Application no: H18-1019-11

Description: Conversion of care home into 12 flats and associated works

Location: Sudeley House
Wharf Street
Sutton Bridge
Spalding
PE12 9UF
PE12 9UF

Amendment: Raised windows to rear (overlooking New Inn) (dwg. nos. SE-026-10B, SE-026-11A, SE-026-12A and SE-026-13A)

Proposed Conversion of Care Home to Flats to Sudeley House, Wharf Street, Sutton Bridge, for Mr. W. Delahoy	Job Title	Date	Scale
	SE-026	December 2011	1:100
Scheme Drawing Elevations & Sections	Job No.	Drawn by	Sheet Size
	12	RS	A1

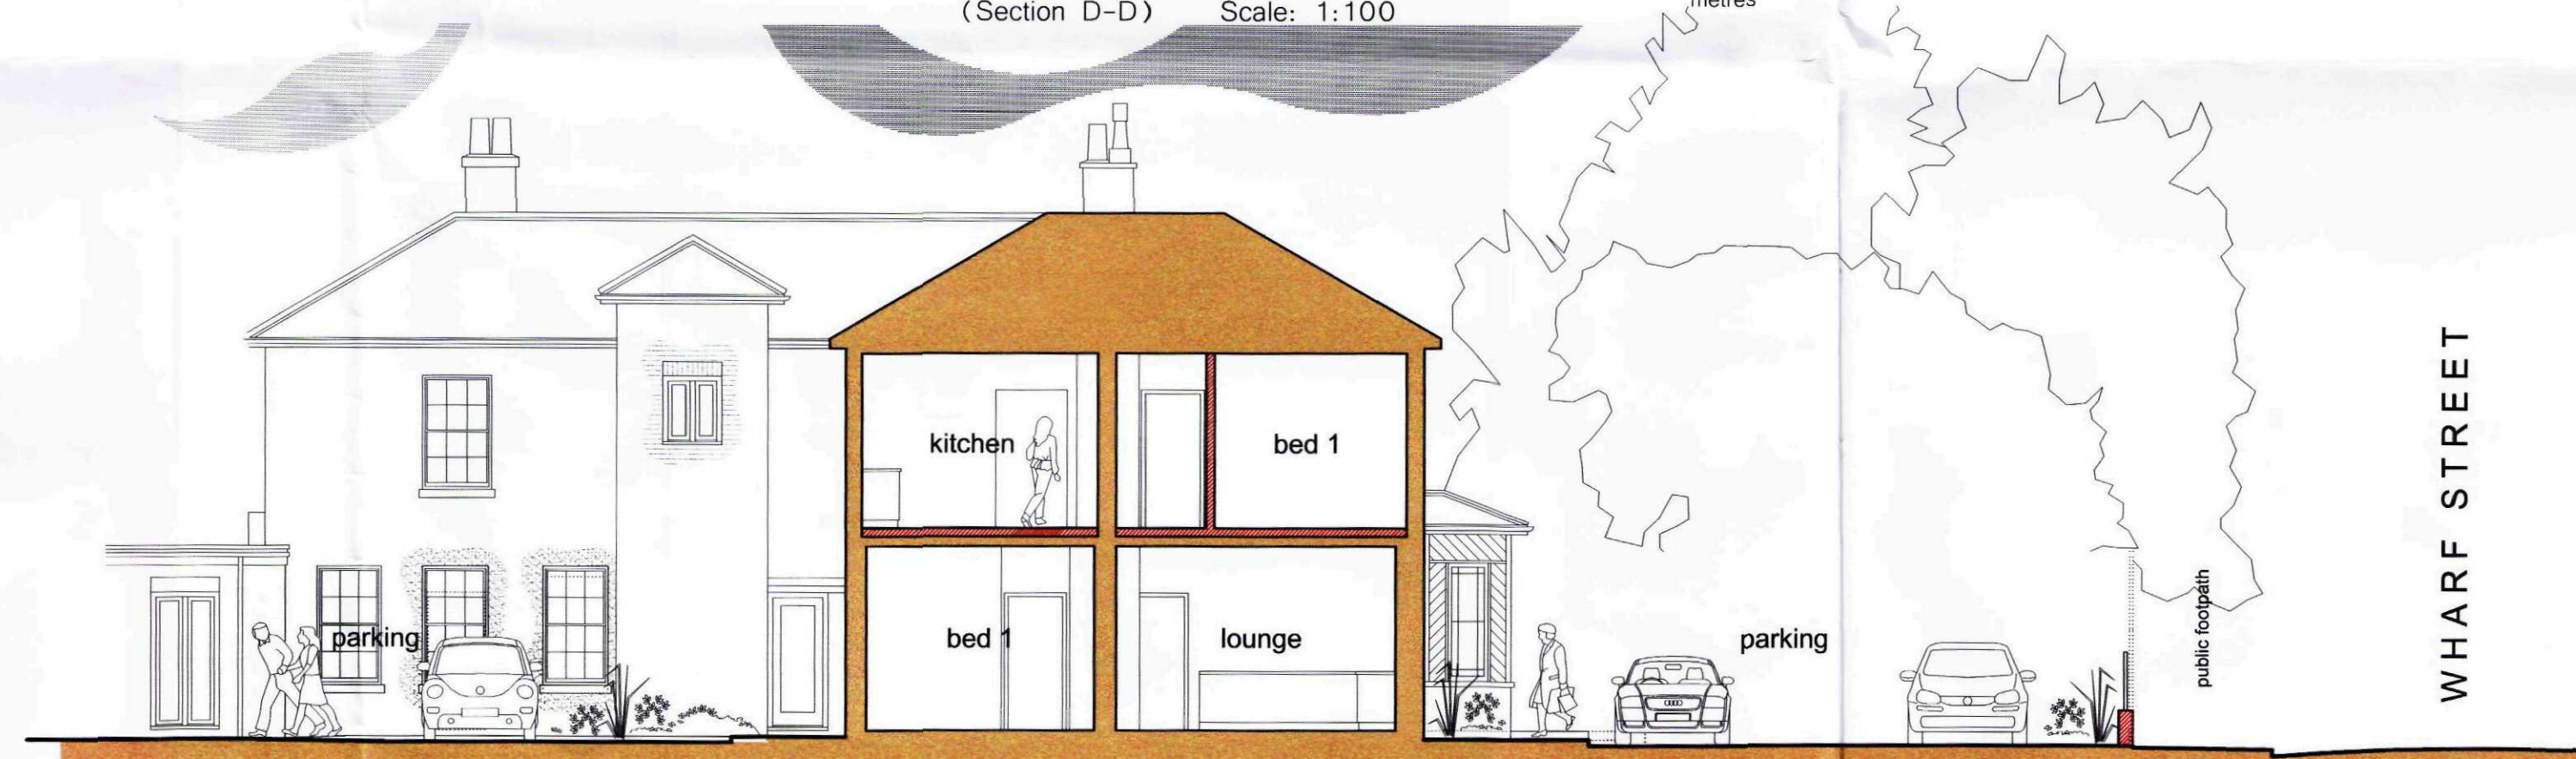
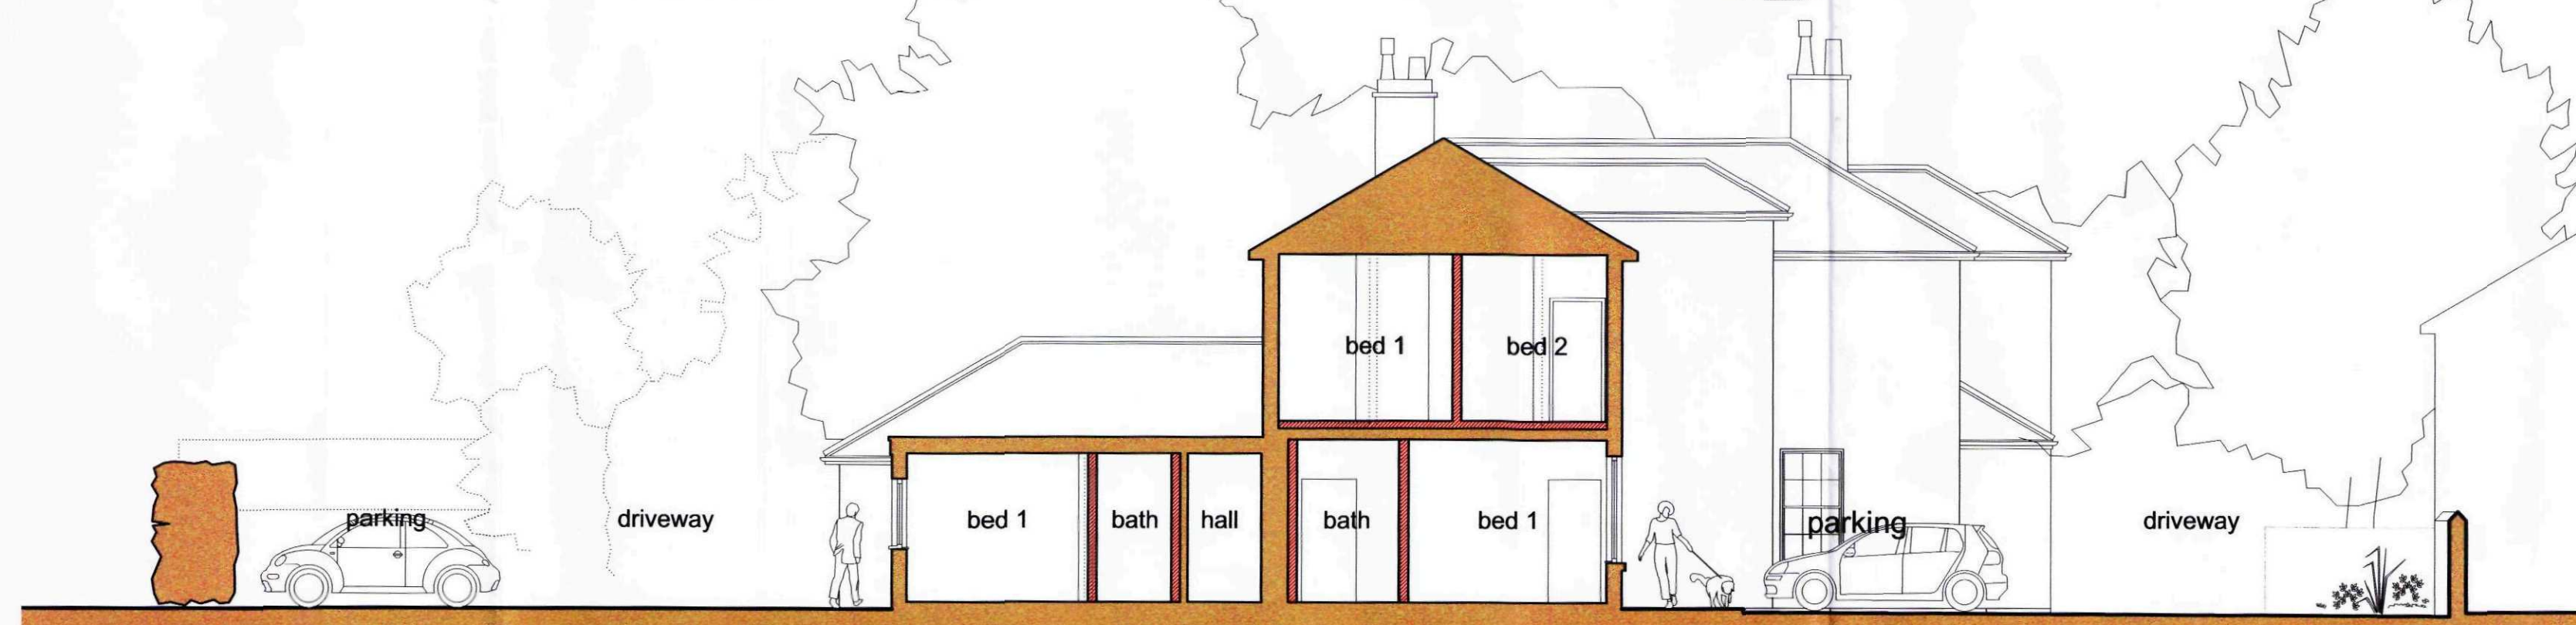
It is noted that the building at the rear is to be heightened and that rooflights are to be inserted. The height of the rooflights will need to be increased to avoid overlooking of windows at the rear of the New Inn and also the rear garden of no 5 Wharf St.

Following your email, please find attached revised drawings as requested. I have raised all of the windows to the rear (overlooking the New Inn) I have not raised the ones facing into our site as we will require these to be escape windows for building control and are therefore as close to 1100mm from the ffl as possible. I hope this is ok. Should you require any further revisions or any more information please do not hesitate to contact me.
